DRB Application No.: 10DRB-70029 Project # 1007864
 Project Name: New Holiday Park
 Agent: Modulus Architects Phone No.: _____

City of Albuquerque
Planning Department
Inter-Office Memorandum

SUBJECT: Project # 1007864

On August 21, 2009, the Environmental Planning Commission approved Project #1007864, 09EPC-40035, a Site Development Plan for Building Permit, for all or a portion of Tract B, New Holiday Park, located on Montgomery Boulevard NE between Juan Tabo NE and Tramway NE containing approximately 4.9 acres.

SHEET TITLE: **SITE PLAN-BUILDING PERMIT**

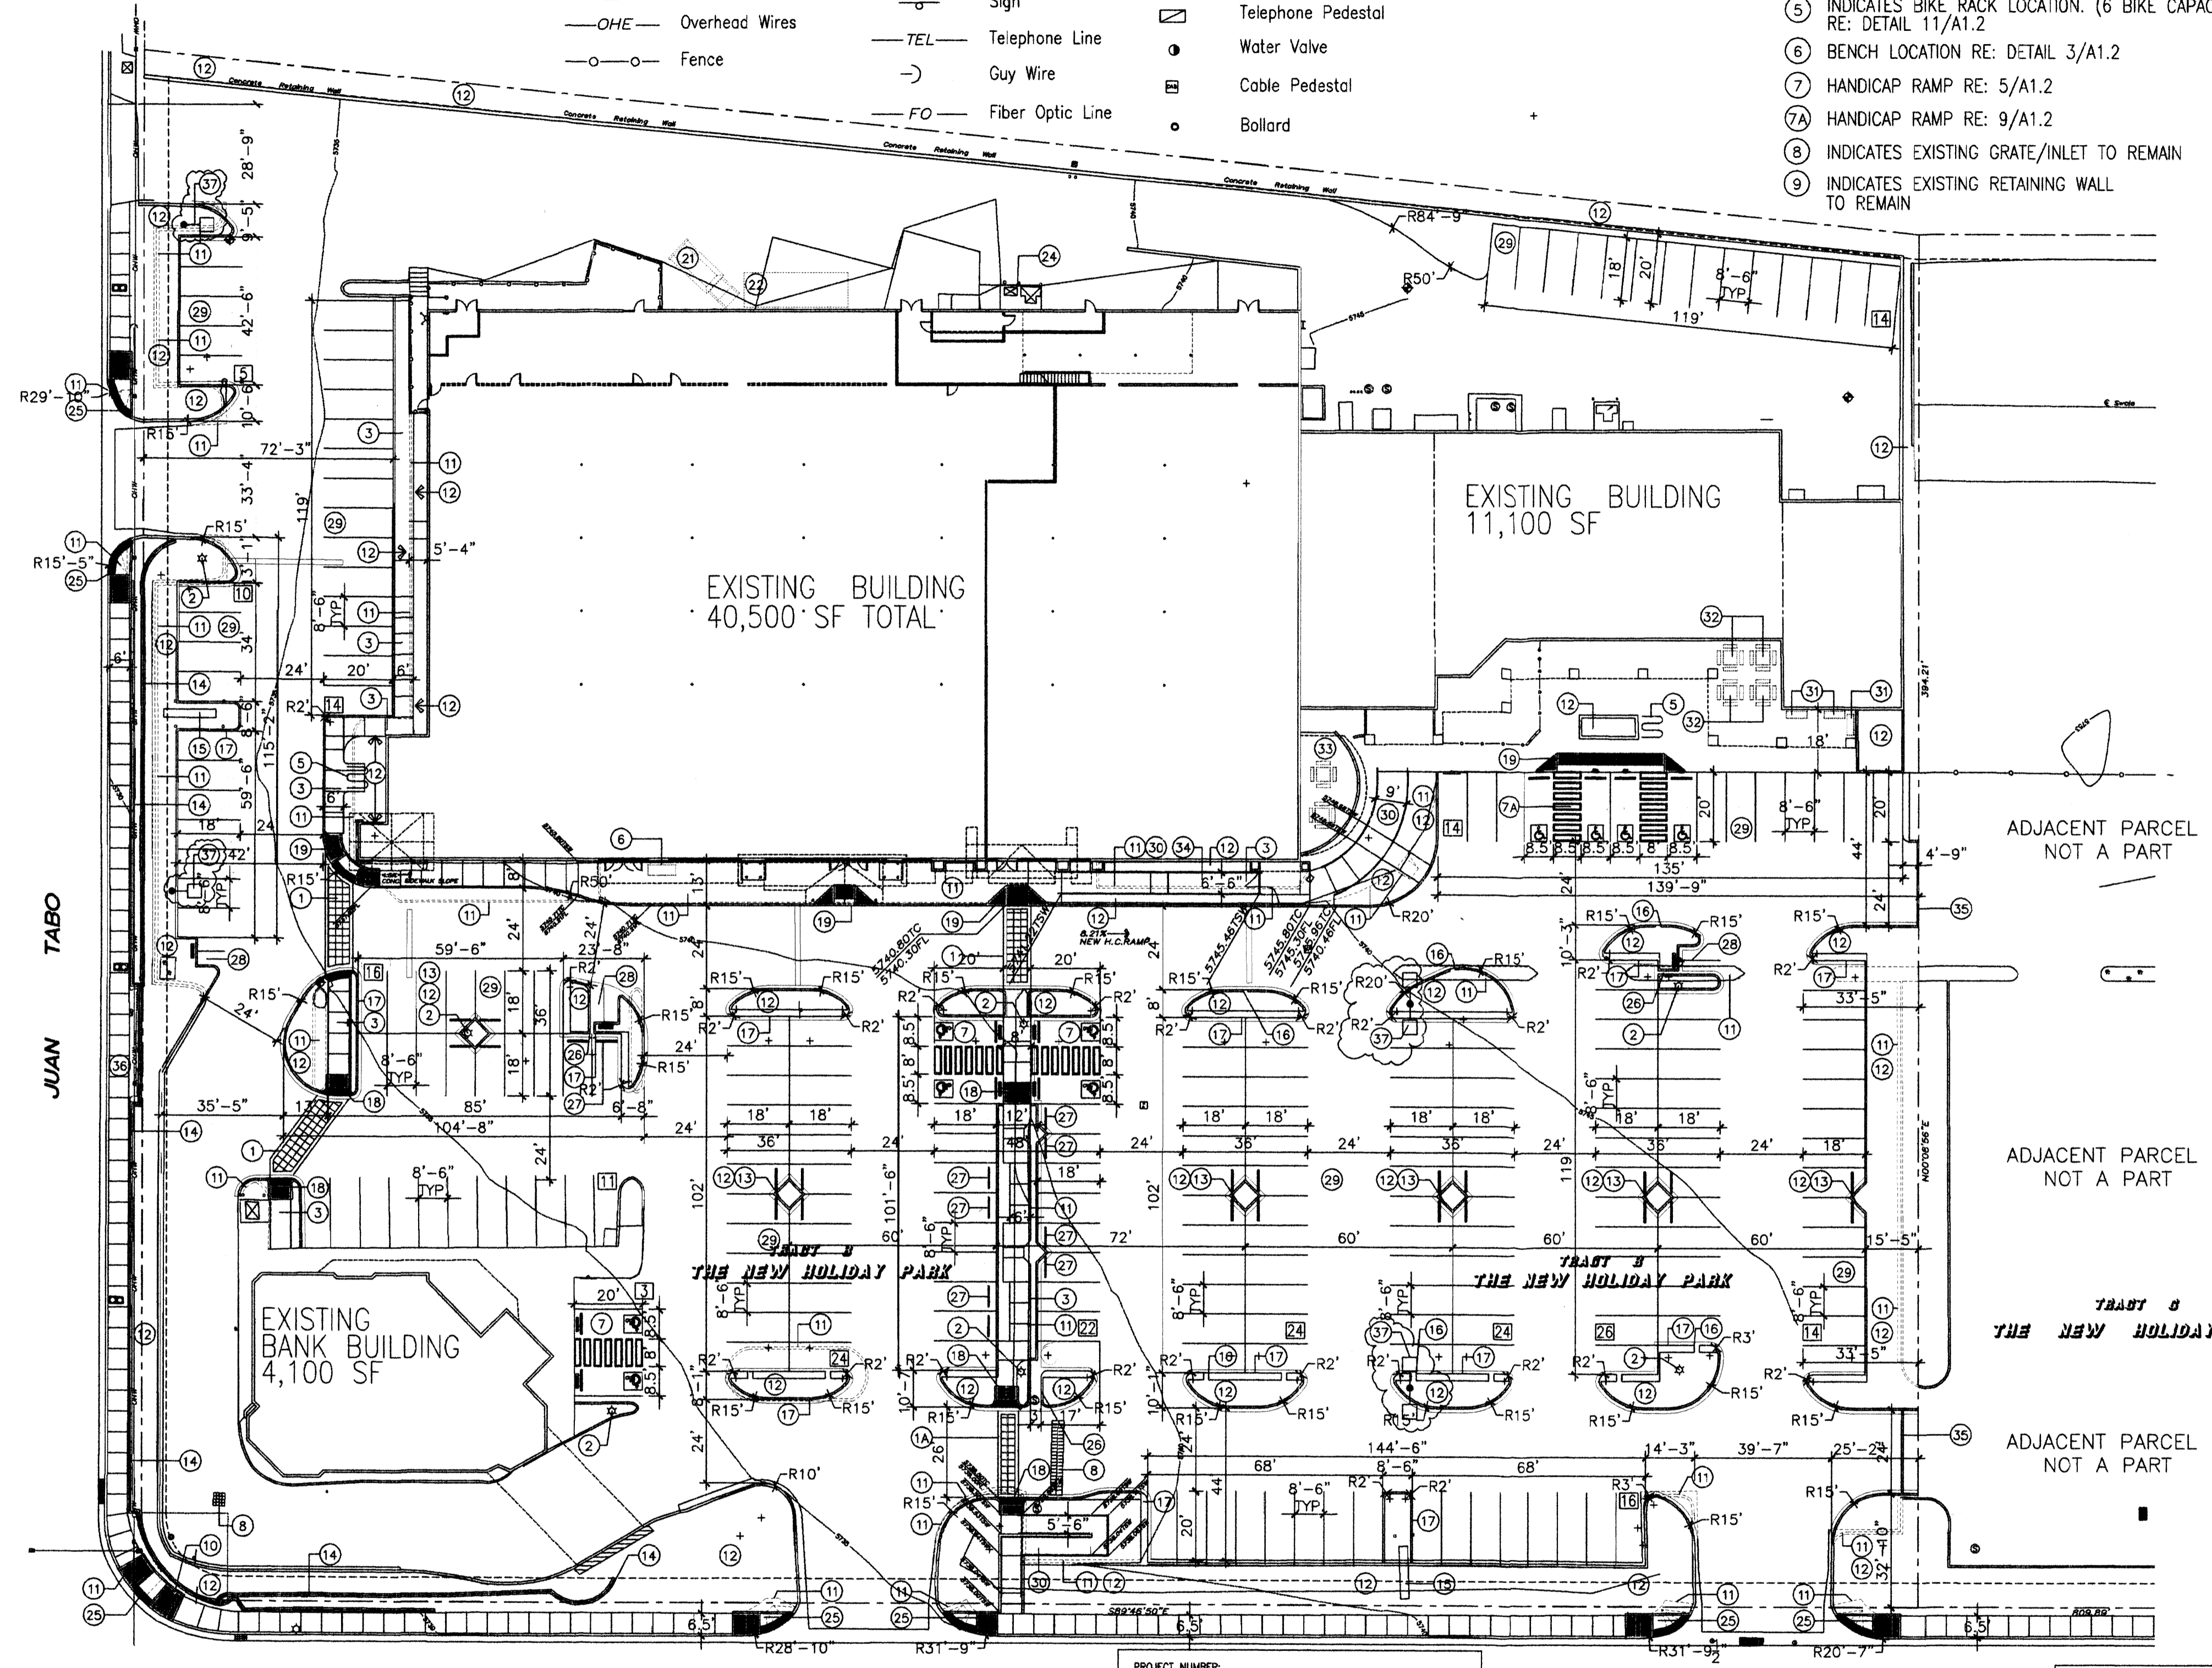
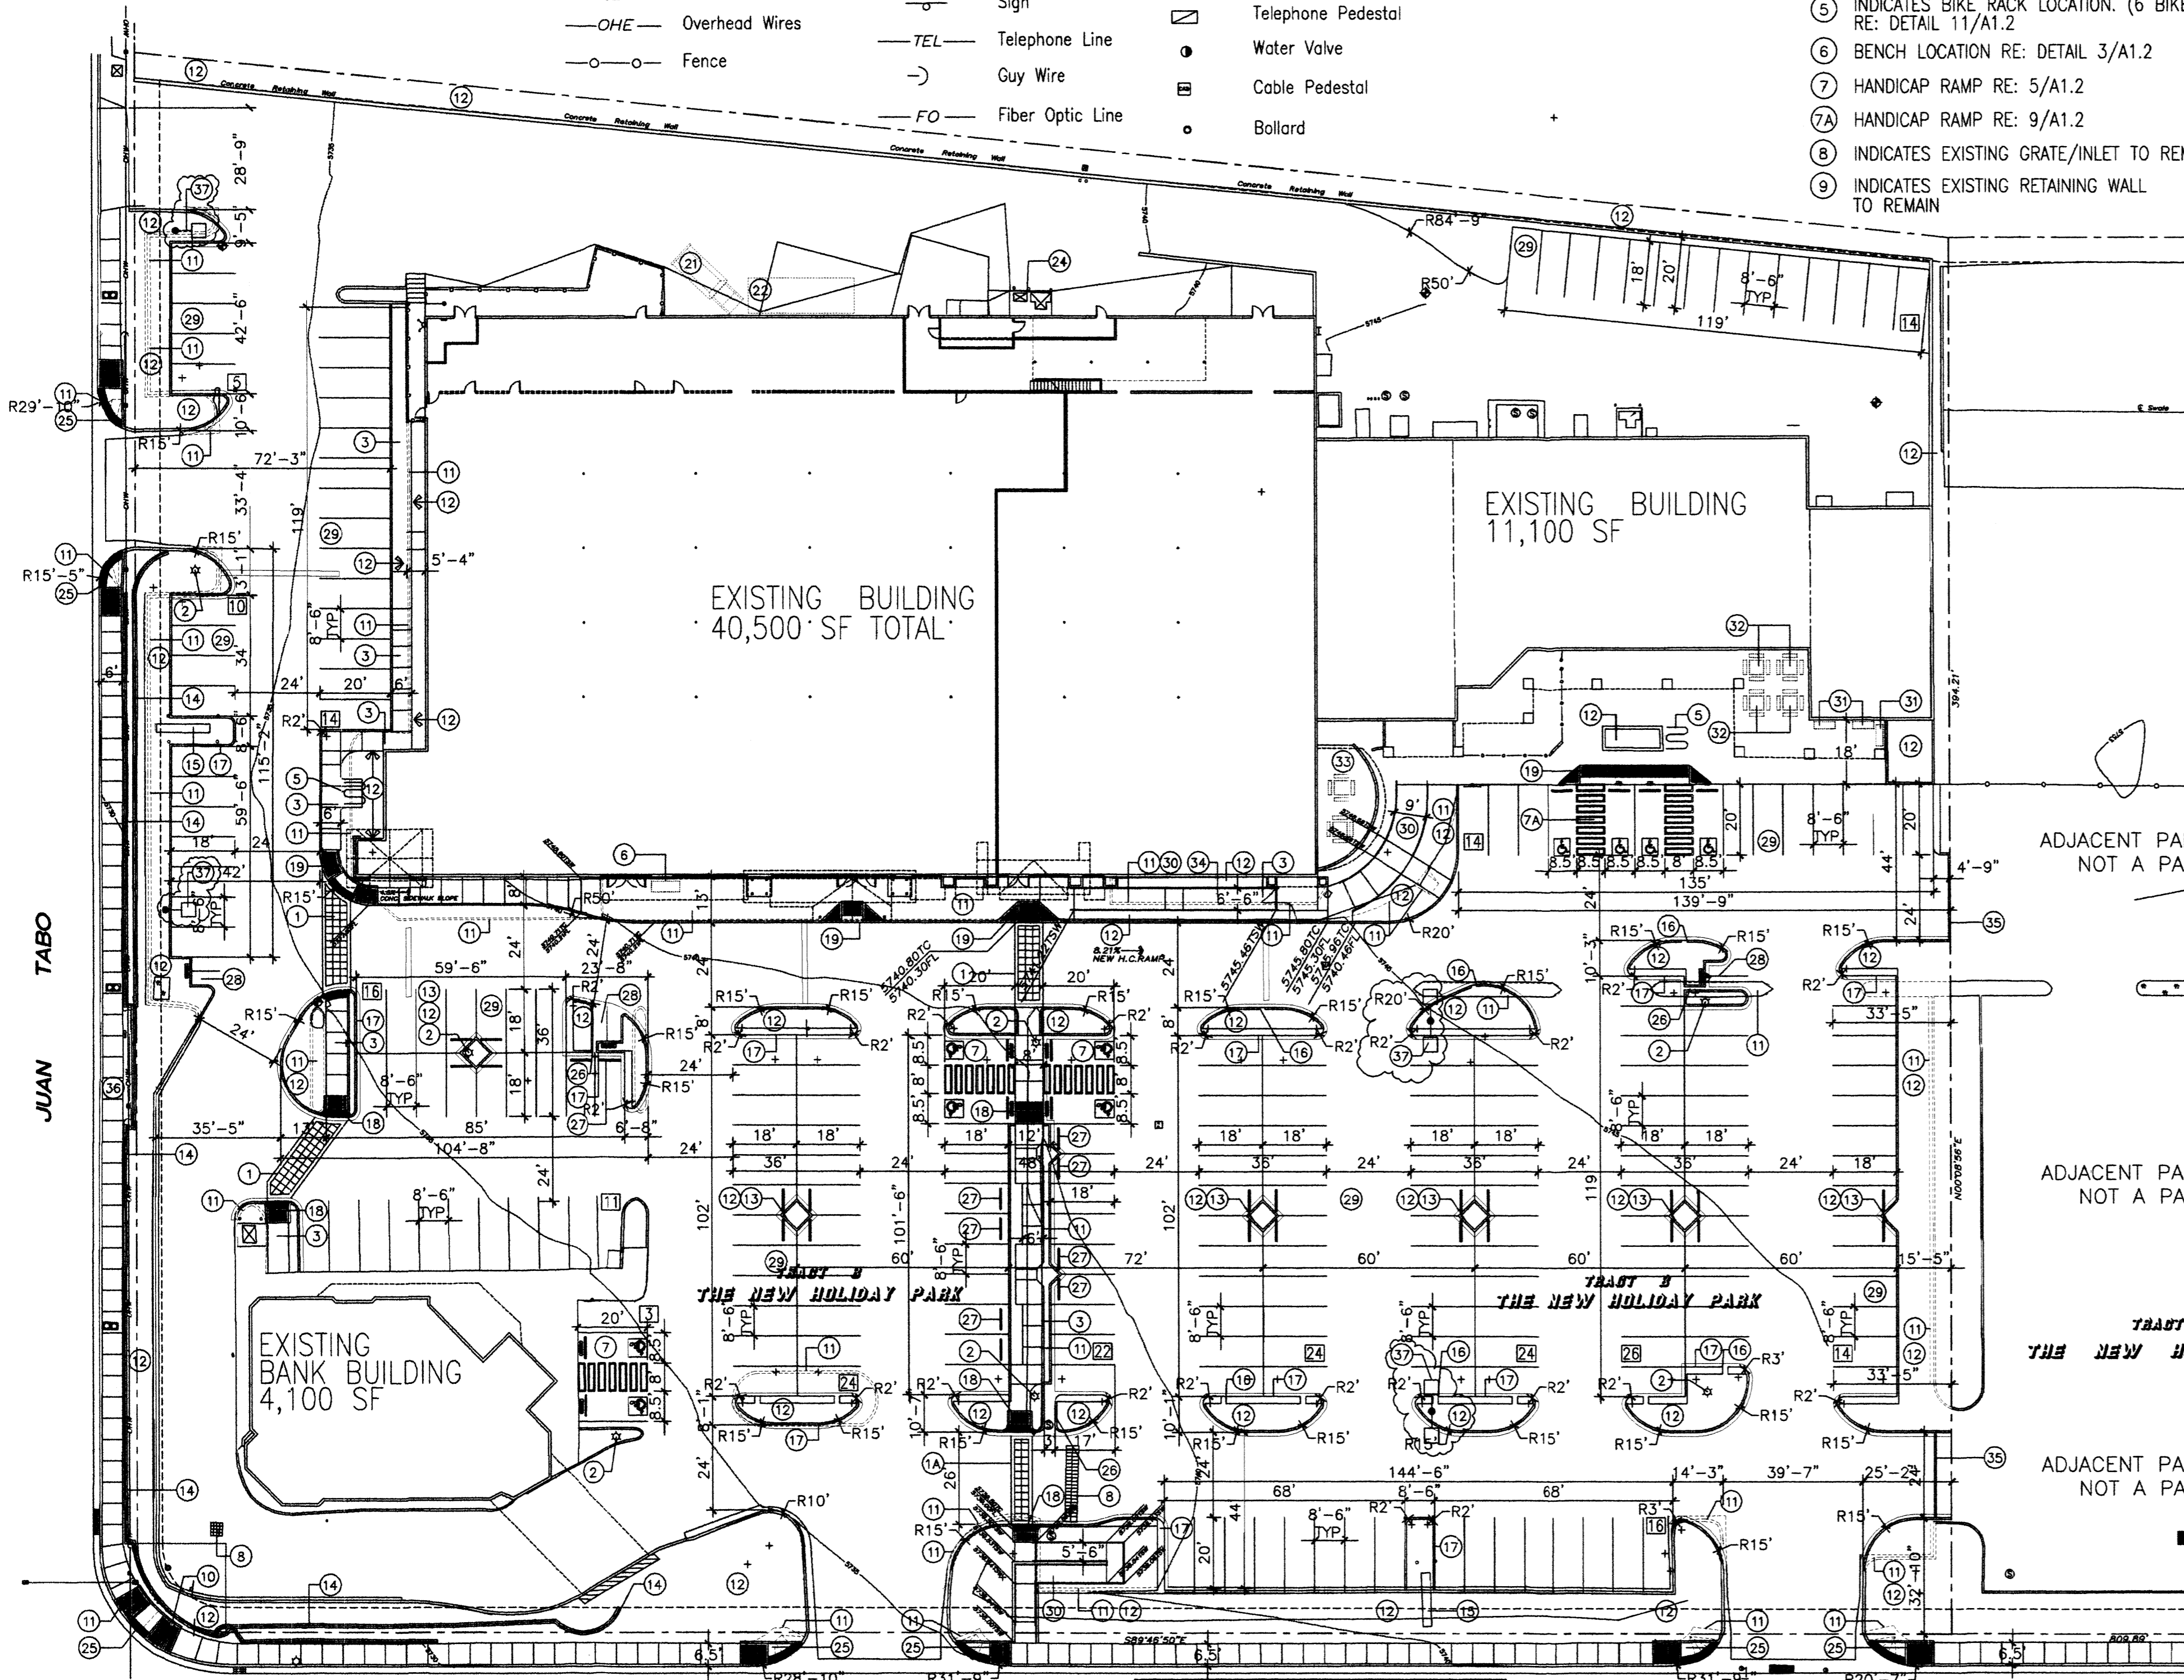
3: The ROW for the principal arterials (Montgomery Blvd. & Juan Tabo Blvd.) shall be provided on the site development plan for building permit.

This has not been done.

5: Total parking provided on the site development plan for building permit shall be changed to accurately reflect existing, proposed and approved spaces.

The following changes need to be made to the Parking calculations: Total parking provided is 238; Bike spaces provided is 12, and bike spaces required is 11.

6: A minimum of 11 bicycle spaces shall be provided, per Section 14-16-3-1 (B)(3). All bicycle racks shall be located along the primary façade (south side) of existing buildings. *The applicant is providing 12 bicycle spaces (with two bicycle racks that provide 6 spaces each); however, not all of the bicycle racks are located along the primary façade (south side) of the buildings. The location of one of the bicycle racks is along the west side of the proposed Sunflower Market building. To comply with the condition it must be placed on the south side of the building.*

12: The transit department requests adequate ROW of 8' wide from the face of the curb and 20' long for the concrete pad along Juan Tabo Boulevard in order to leave space for a future bus shelter at the existing bus stop.

The location of the proposed bus shelter has been identified on the site development plan for building permit; however, the exact specifications (ROW of 8' wide from the face of the curb and 20' long for the concrete pad along Juan Tabo Boulevard) also need to be on the site plan.

15: Parking lot corrals shall be added to the site to help prevent loose carts and denting of vehicles.

This has not been done.
